Your Ref :
Our Ref : BR/11/18/NMA

Section 96A of the Town & Country Planning Act 1990 (as amended)
Town and Country Planning (Development Management Procedure) (England) Order 2015 (as amended) - Article 10

Application for a non-material amendment following a grant of planning permission BR/153/16/PL relating to retain the ground floor small retail unit, together with reconstruction of the existing first floor flat kitchens & incorporation new roof lights to allow the creation of a new first floor flat with access stair & balcony with alterations to retain access to the existing first floor flats 55 & 57 London Road, Bognor Regis, ,

Title
Plans Revised Bedsit Layout

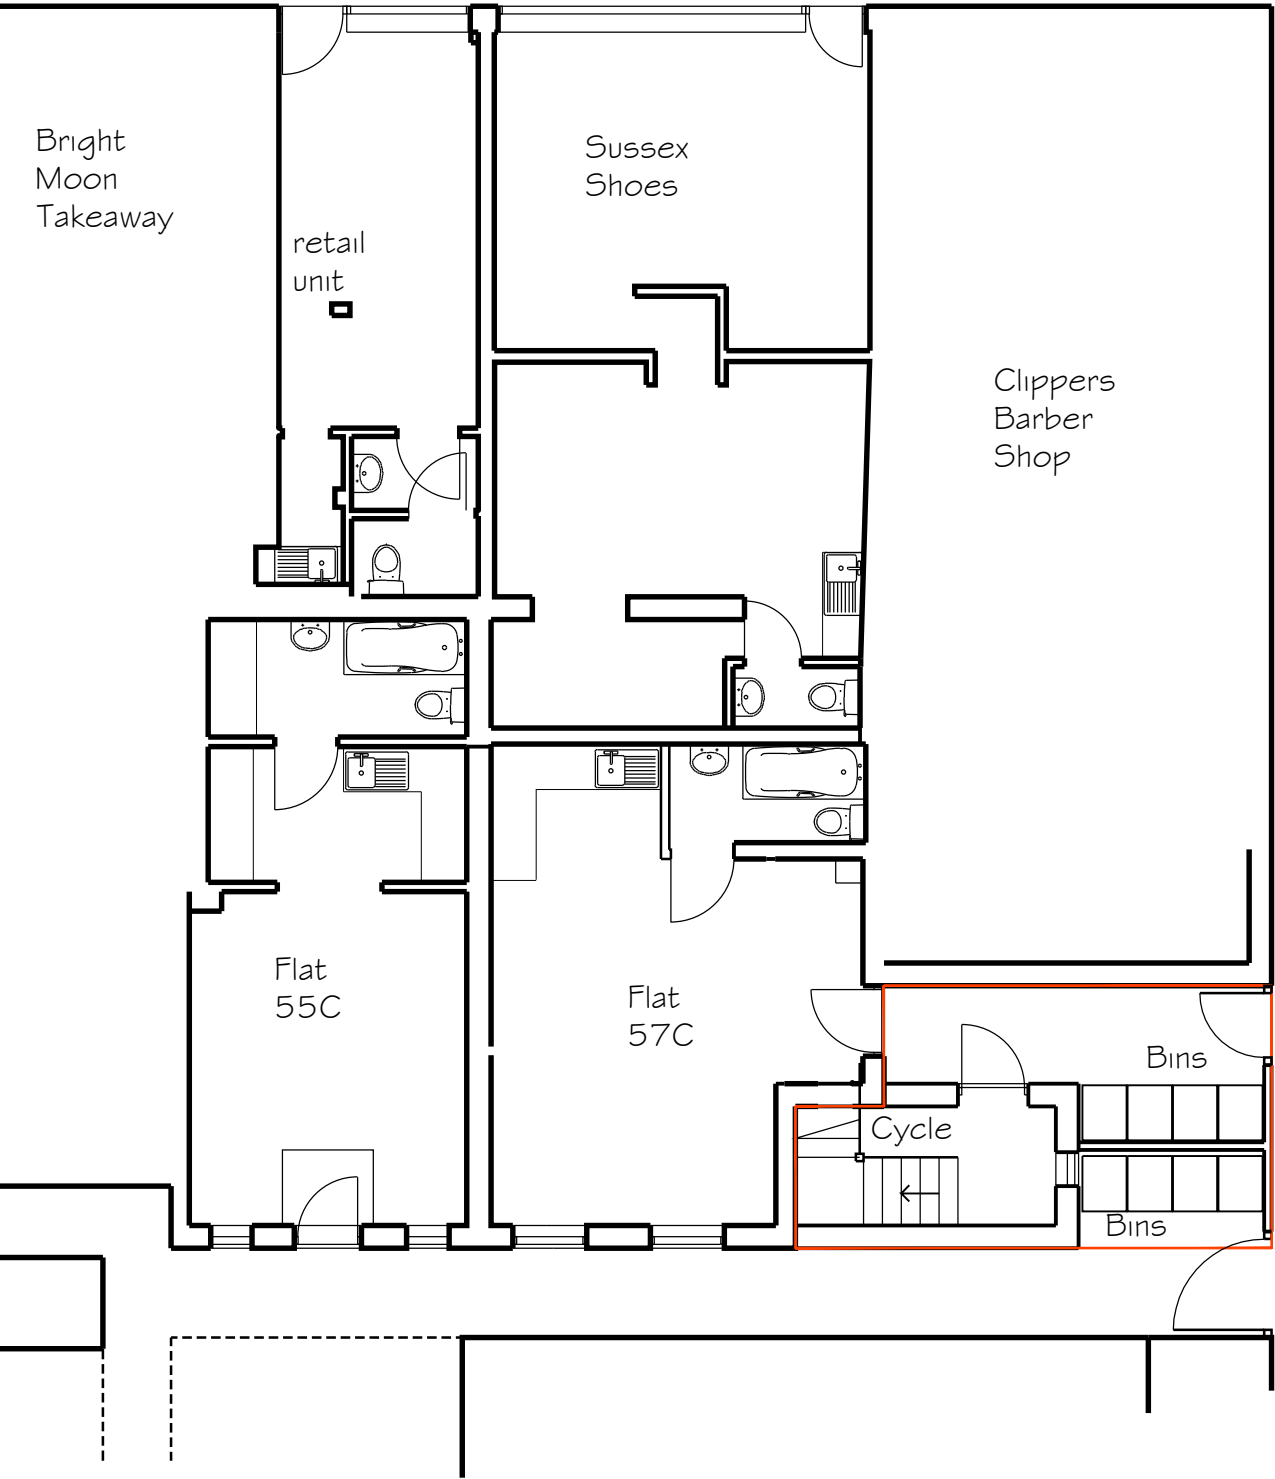
I refer to your recent application for a Non Material Minor Amendment (NMA). I note that you propose to amend the layout by creating an external landing area at the expense of floor space for existing flat 55A and new flat 57B.

Unfortunately, I am unable to accept the proposal as a NMA because the change to the layout results in a reduction of the internal space for new flat 57B from 42m² to 39m². The requirement within the planning practice guidance for this flat is 50m² and whilst we previously agreed an 8m² deficit, we cannot approve a further reduction. Furthermore, I note that whilst the original permission increased the internal space for existing flat 55A by 5m², the result of this proposal is a net loss of 7.6m² space to that flat.
